From: Sarah Burrow <Sarah.Burrow@arun.gov.uk>
Sent: 10 August 2021 11:39
To: Planning.Responses <Planning.Responses@arun.gov.uk>
Cc: Daniel Vick <Daniel.Vick@arun.gov.uk>
Subject: AL/79/21/DOC

Engineers Comments Relating to Surface Water Drainage

PROPOSED
FLOOR PLAN & SECTION

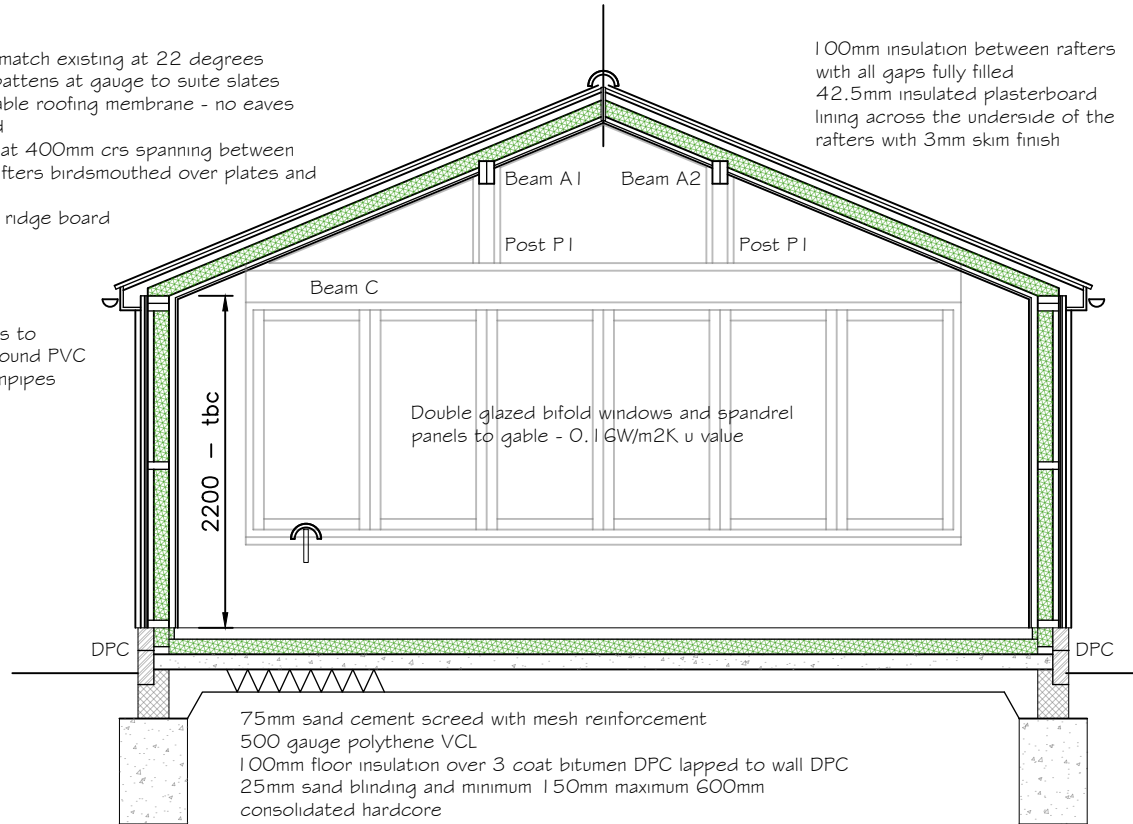
A proposed floor plan has been supplied which shows the approximate drainage layout. We would require more detail on a detailed drainage layout in order to recommend that Condition 3 is discharged. The soakaway that is shown on the layout appears to be undersized and the calculations to support the sizing are not in accordance with BRE365 or any other approved method.

In order to discharge the condition the applicant will need to supply appropriate calculations to size the soakaway (on the basis of the on-site infiltration rate), a more detailed drainage layout (please see our drainage checklist linked below and pay attention to note 10) plus construction detail drawings (note 11 on same drainage checklist) for all components.
